Re: Noah's at Fountain Plaza Grading and Drainage Plan (C12/D003B4)

The following is in response to Ms. Amy L.D. Niese comments dated September 30, 2014.

**Re: Noah's at Fountain Plaza
Grading and Drainage Plan
Engineer's Stamp Date 9-15-14 (C12D003B4)**

Based upon the information provided in your submittal received September 24, 2014, the above referenced plan cannot be approved for Grading Permit nor Building Permit until the following comments are addressed:

FOR INFO ONLY	ENGINEER'S SEAL	NOAH'S EVENT CENTER	DRAWN BY DEM
			DATE
		CONCEPTUAL GRADING AND DRAINAGE PLAN	5-2014
			visitors must comply with all rules
			SHEET #
			3 of 6
			JOB #
			5844.86

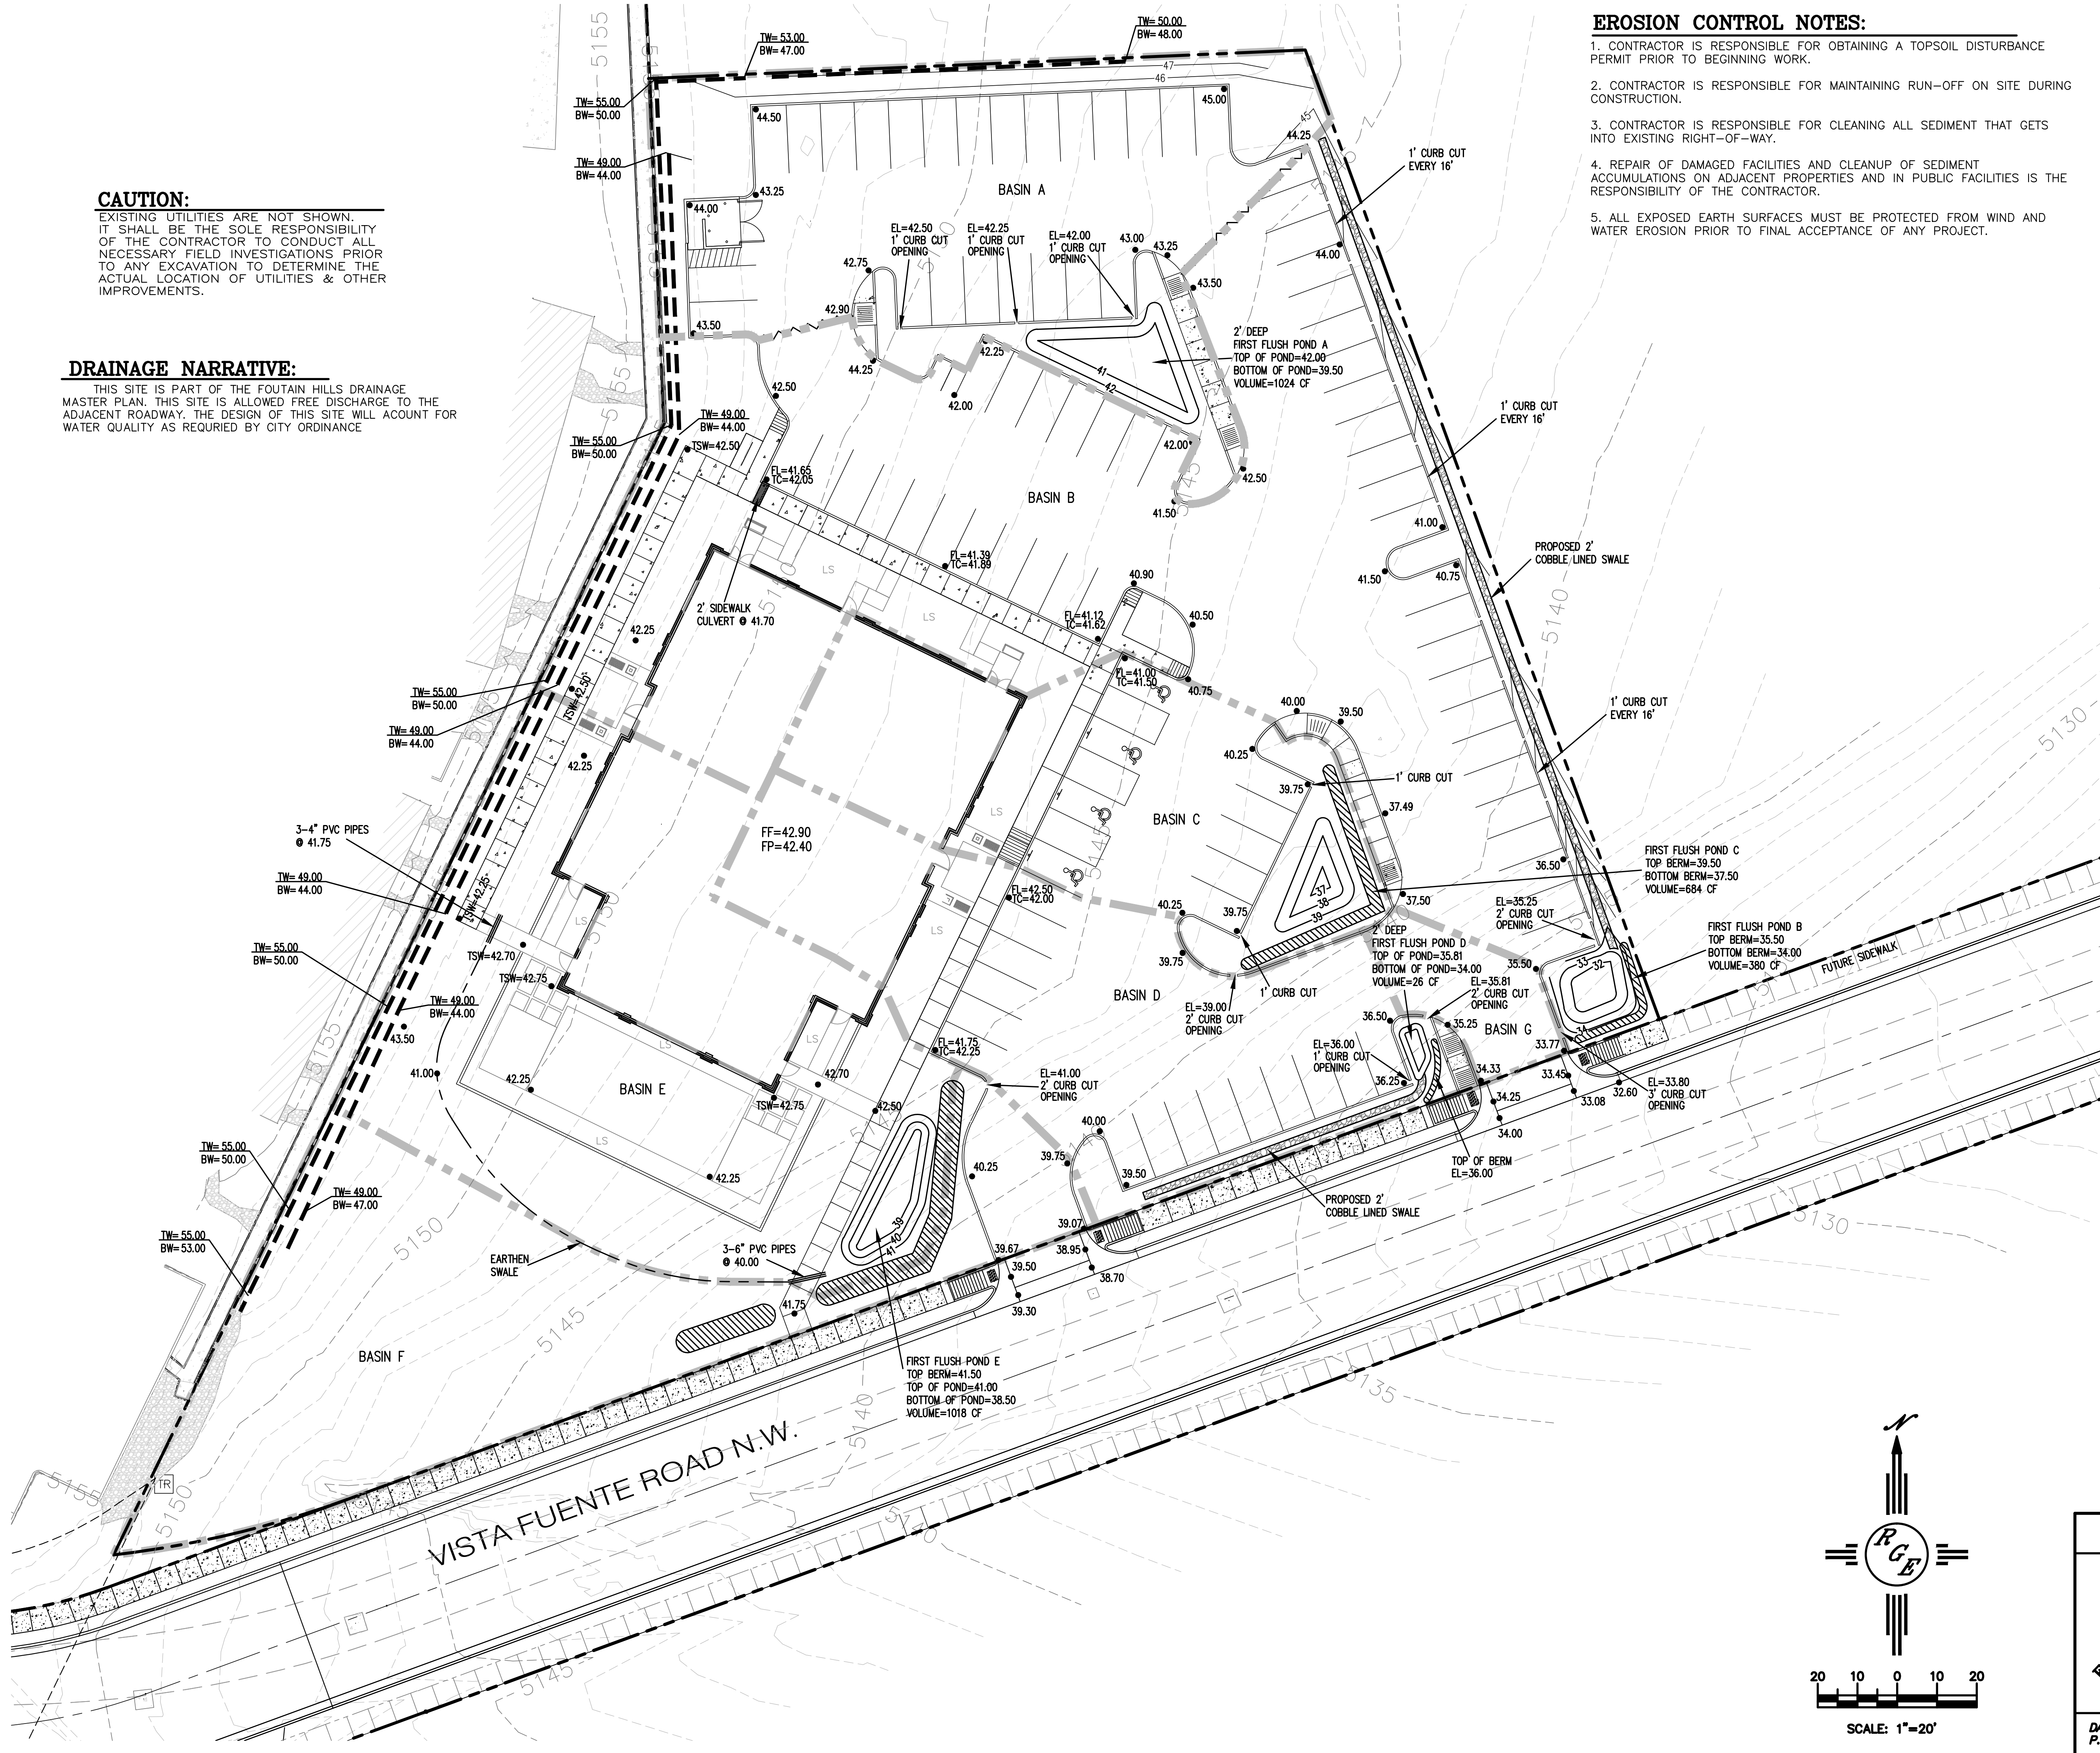
2. Calculations were provided for the First Flush. (Please note, use "First Flush" instead of "Water Harvesting".) Your design was for the area of the site times 0.34 inches. The ponds can be sized for the impervious area times 0.34 inches.

3. The contour elevations of the First Flush ponds do not match what is being called out in the text for the ponds. Please revise.
4. How is the site tying into exiting grades along the perimeter? Provide contours or spot elevations showing how that is being accomplished.

5. Provide bottom of wall elevations where sidewalk elevations are called out.
6. Include calculations showing the 18 inch laterals are sufficiently sized.

2. The ponding capacity provided for the first flush ponds is larger than required, as mentioned in the above referenced letter. It is desired to retain the ponds as shown on the grading plan.

3. The elevation contours for the first flush ponds have been corrected.
4. Elevation contours have been added to address the concern regarding how this site will tie into the adjoining property to the east. There are proposed retaining walls on the other two sides, the top of wall and bottom of wall elevations are included.

5. Bottom of wall elevations are included on the grading plan where sidewalk elevations are called out.
6. Calculations showing the 18in laterals are sufficiently sized are included, refer to sheet 3.

PAVING IMPROVEMENTS
VISTA FUENTE RD

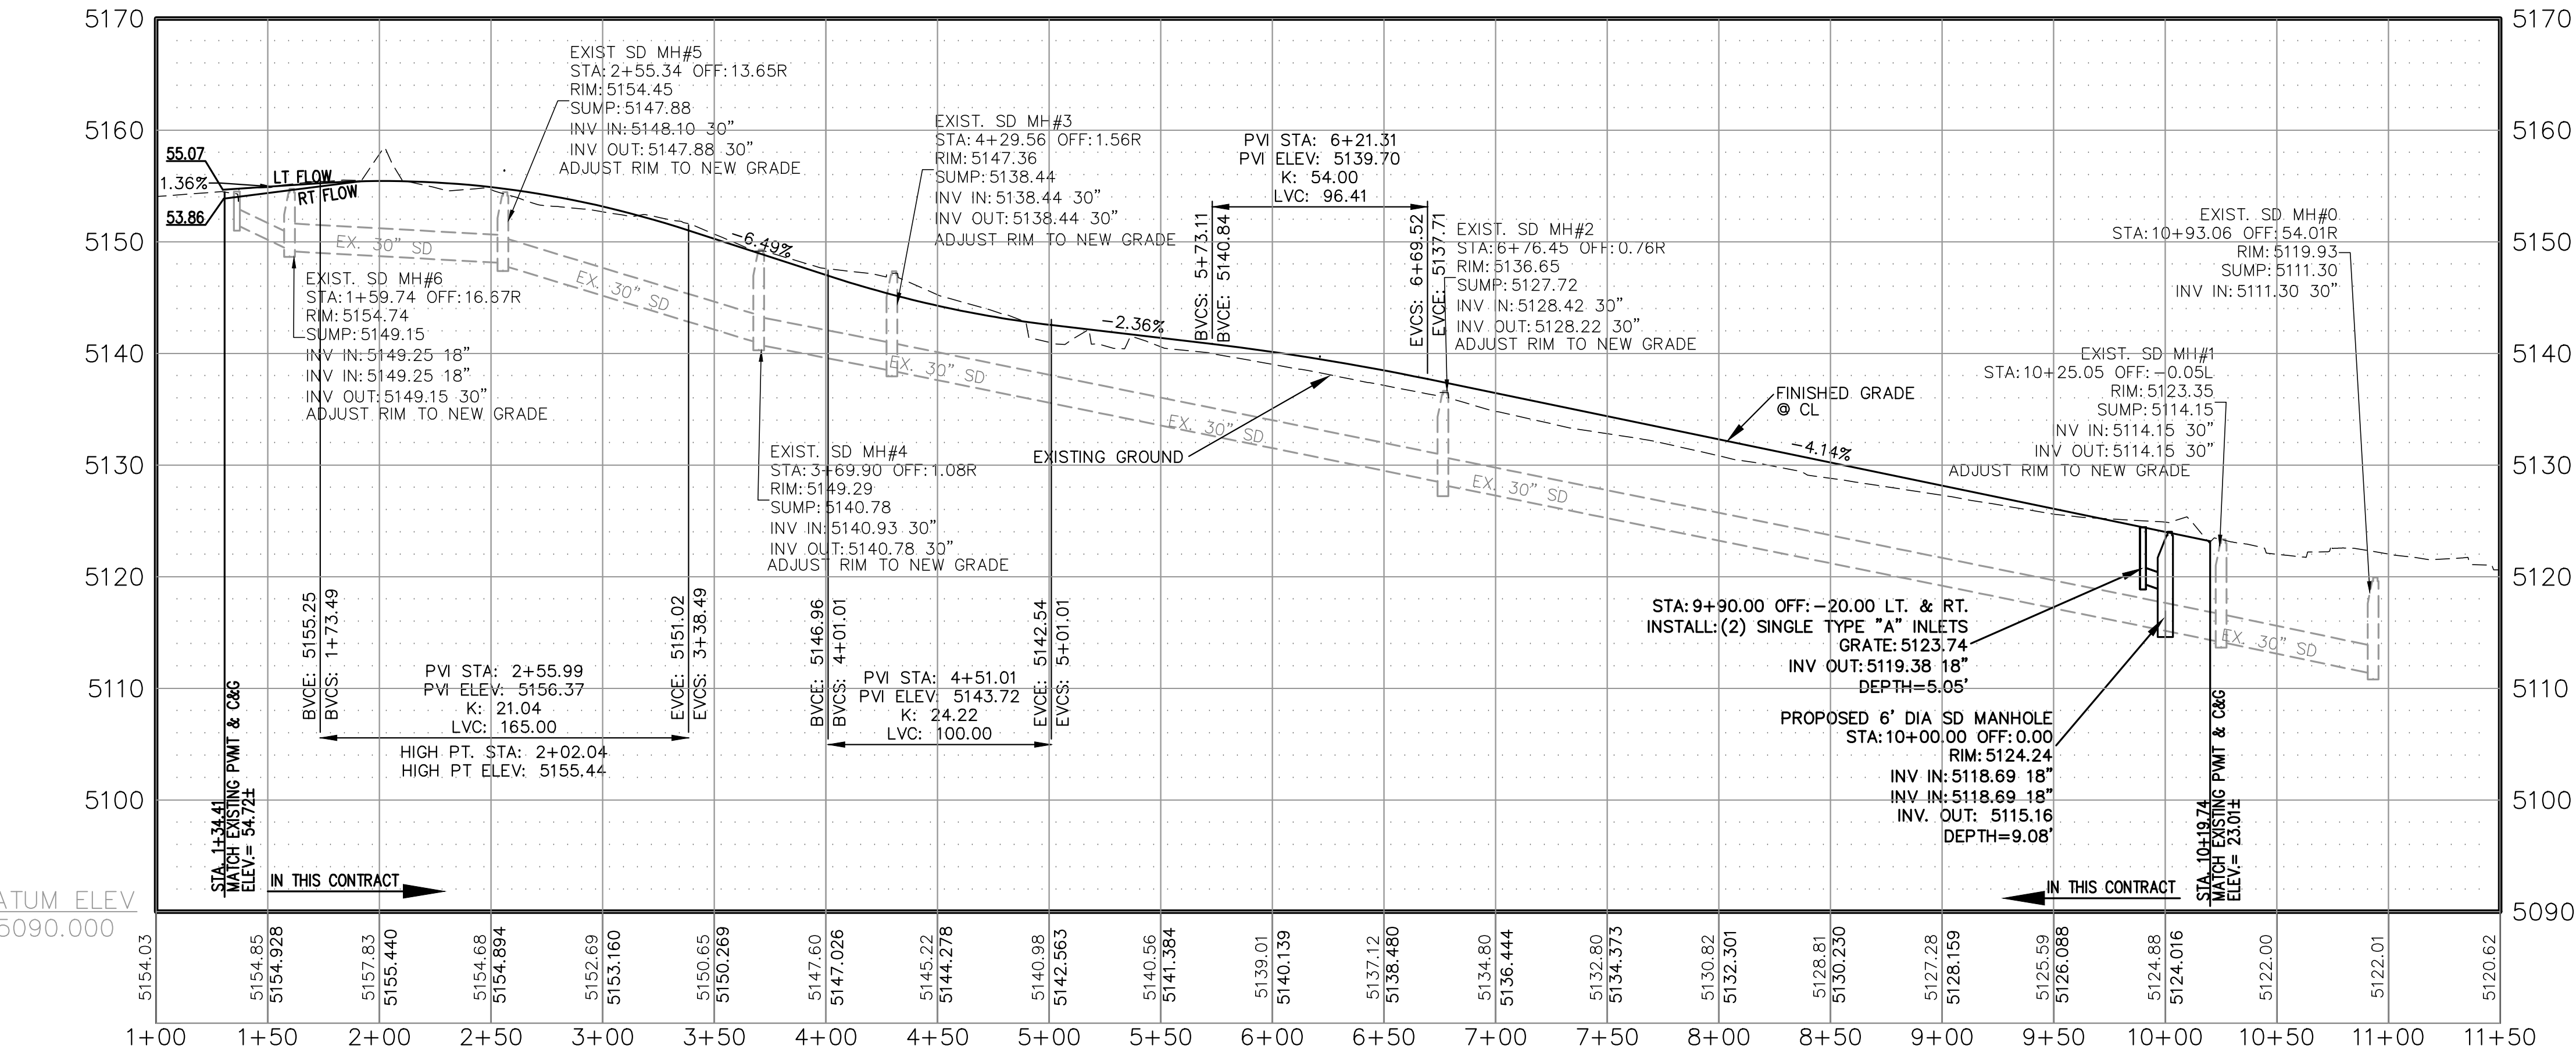
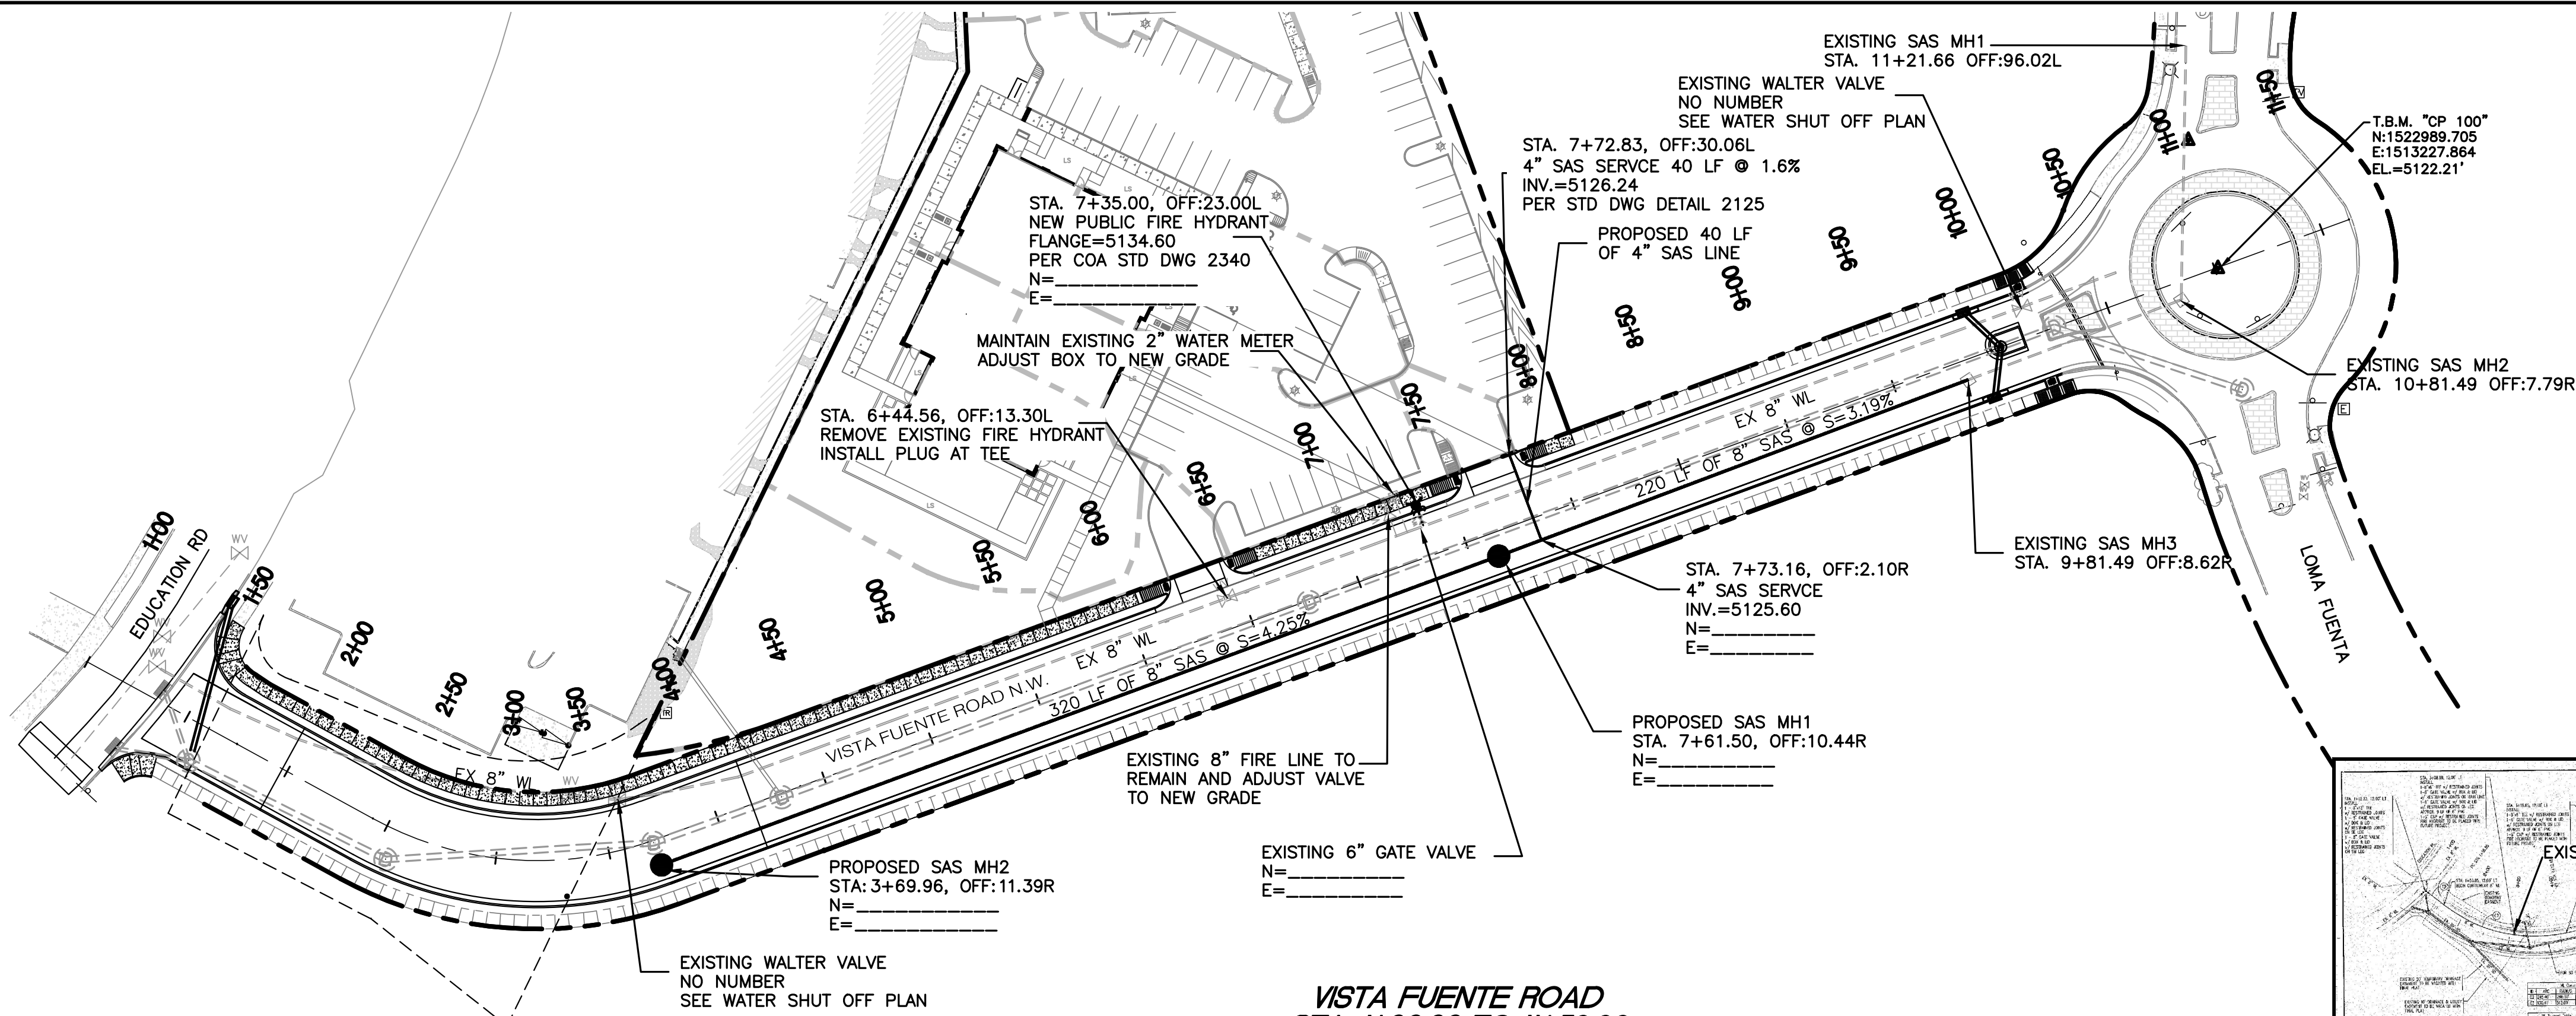
1. As we discussed, the area provided for Vista Fuente Road should be the full length of the road before the proposed inlets which was your original intention. The area provided is not accurate which will impact the sizing of the inlets. Provide the revised area and associated calculations.

1. The entire length of Vista Fuente Road is included in the calculation for the street flows on the addendum (attached). The new calculations for the street flow is 9.17 cfs on the north side of the street and 1.65 cfs on the south side of the street. The total street flows are 10.82cfs, refer to sheet 1 and sheet 2.
